**Application by Cottam Solar Project Ltd for an Order Granting Development Consent for Cottam Solar Project  
The Examining Authority's first written questions and requests for information (ExQ2)  
Issued on 16<sup>th</sup> January 2024**

**WEST LINDSEY DISTRICT COUNCIL (20037171)**

Answers to Examining Authority's Questions (ExQ2)

Cottam Solar Project EN10133

**Figure A.15.1 Noise Monitoring Locations**

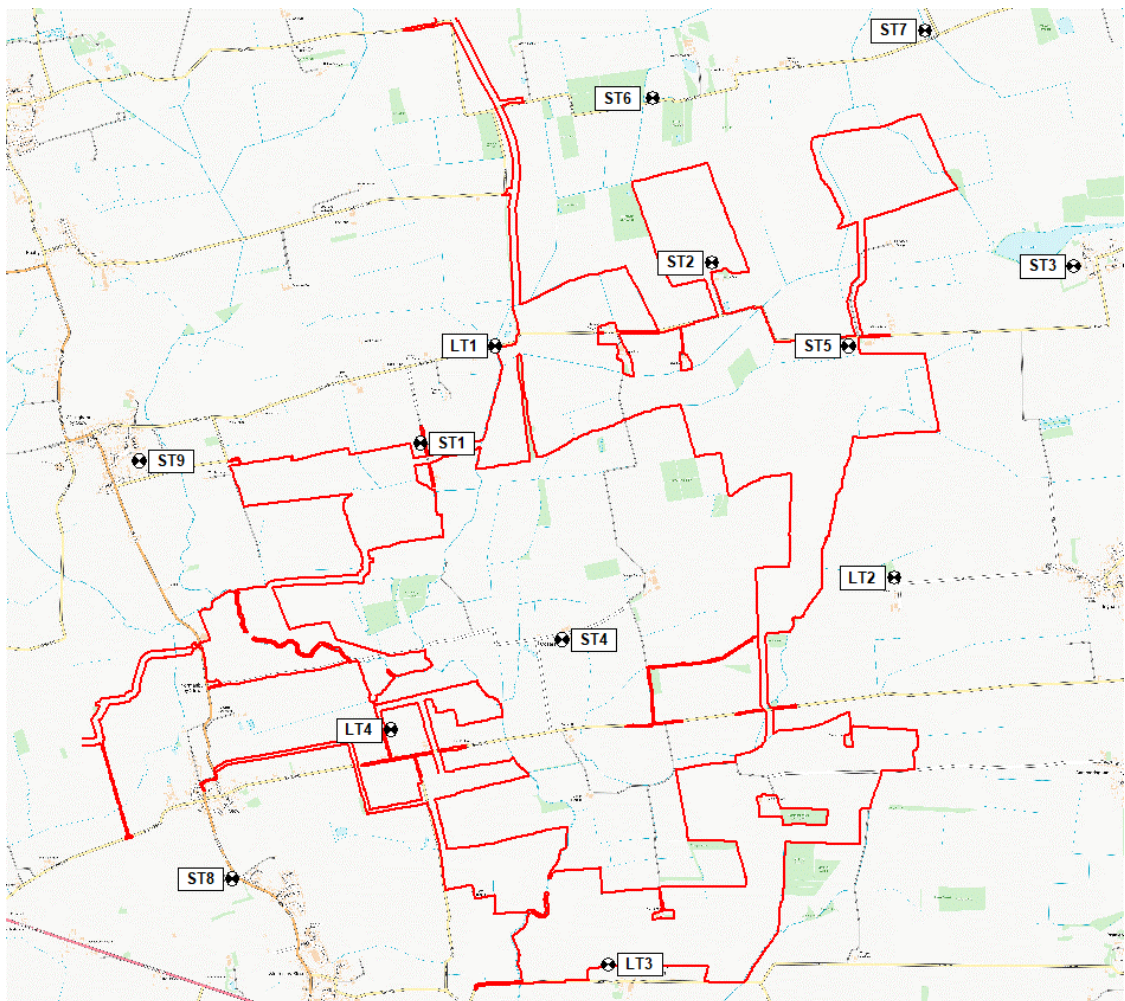
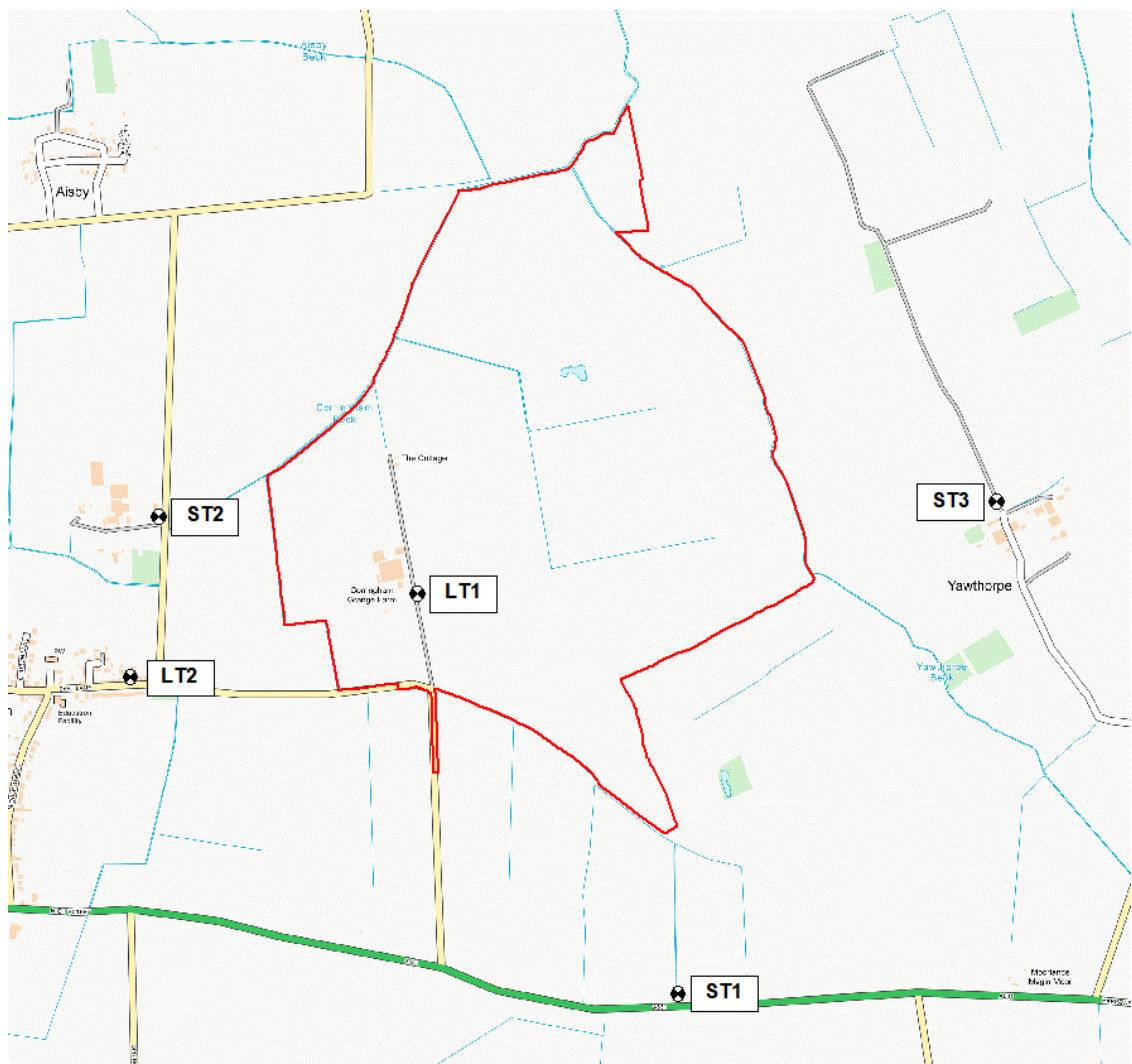
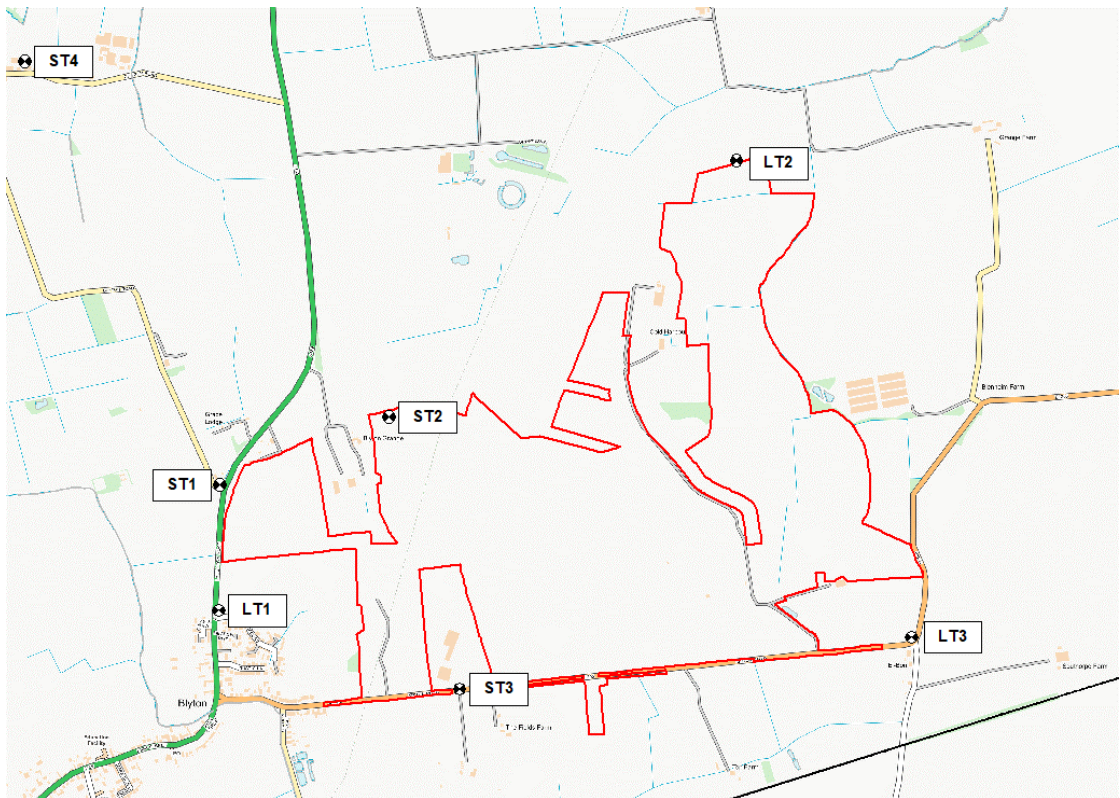
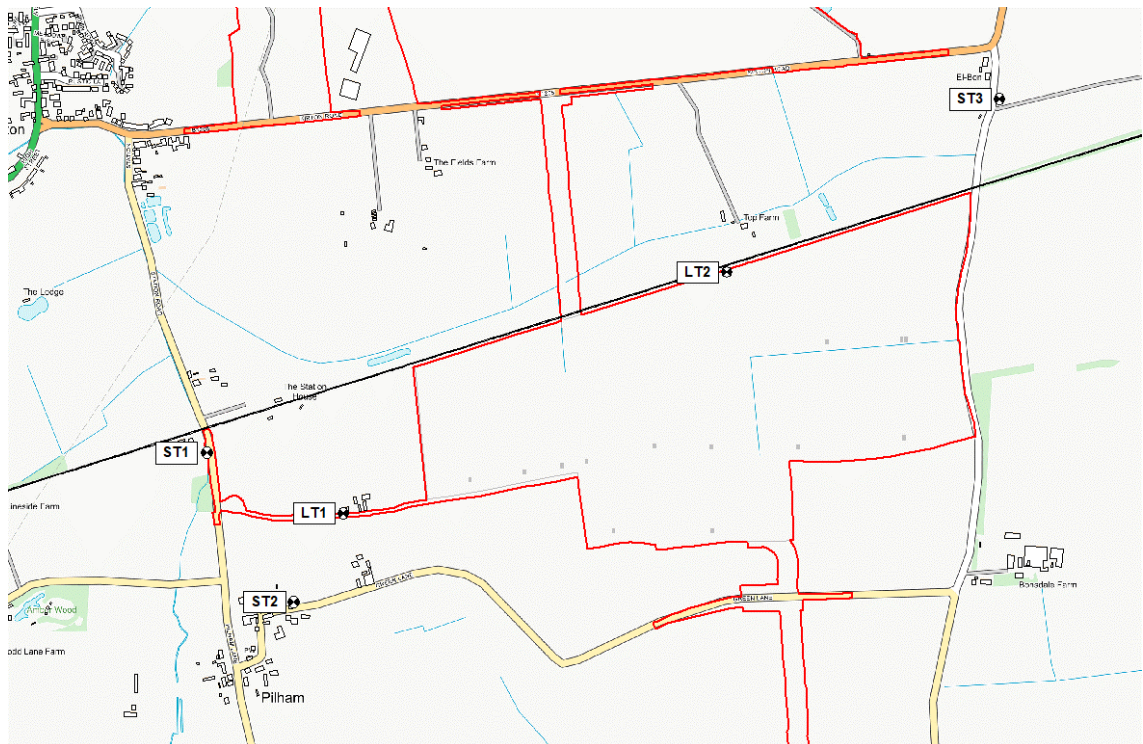
2.11.2	WDLC	<p>The Applicant responded to the Council's comments in its LIR on the noise methodology, surveys, sources and assumptions in its Response to LIRs [REP2-047]. Has this addressed the Council's concerns?</p>	<p>Following consideration and review of the Applicant's responses to its LIR comments, WLDC's position on each point are as follows:</p> <ol style="list-style-type: none"> <li>1. WLDC welcomes confirmation that the magnitude of effect criteria for construction noise has been mapped incorrectly and the clarification that, notwithstanding this, the construction noise assessment has utilised the correct threshold value for significance (65dB). This clarification has addressed WLDCs concerns.</li> <li>2. The clarification of the approach adopted within the cable route corridor is helpful. This addresses WLDCs concerns with regard to the specific issue raised, but it is noted that exceedance of the 70dB threshold at three receptors remains an assessed impact.</li> <li>3. The response does not adequately address the matter raised by WLDC. The response cites that information on the noise assessment locations are</li> </ol>

EXQ2	Question to	Question	WLDC Response
			<p>'summarised' in Chapter 15, para. 15.5.5 / 6, however these paragraphs do not provide a description of each location. The Applicant's response states that "full details of the noise monitoring surveys are presented in Appendix 15.1" however this Appendix simply identifies each location on a map and records the assessment results. There continues to be no information on the physical characteristics of each assessment location, which WLDC would expect to find within the ES.</p> <p>4. The Applicant's response is noted, however, WLDC are seeking more detailed descriptions of locations to validate that appropriateness of the proxy locations to the receptors.</p> <p>5. The applicant's response has misunderstood the matter raised by WLDC. The adopted Scoping Opinion (March 2022) states (ID 3.10.2) that whilst the Inspectorate was content to 'scope out' vibration effects during operation, it also adds that "The ES should describe the potential sources of vibration arising from the operation of e.g. substation and battery storage infrastructure and any measures to control emissions". The applicant refers to ES Ch15 section 15.7, however this does not provide such a description. The ES is therefore wholly silent on any potential sources of operational vibration. The Applicant's response does not therefore address the matter raised and WLDC would welcome clarification on this matter.</p> <p>6. WLDC notes the response from the Applicant; however, it does not address the matter raised. The</p>
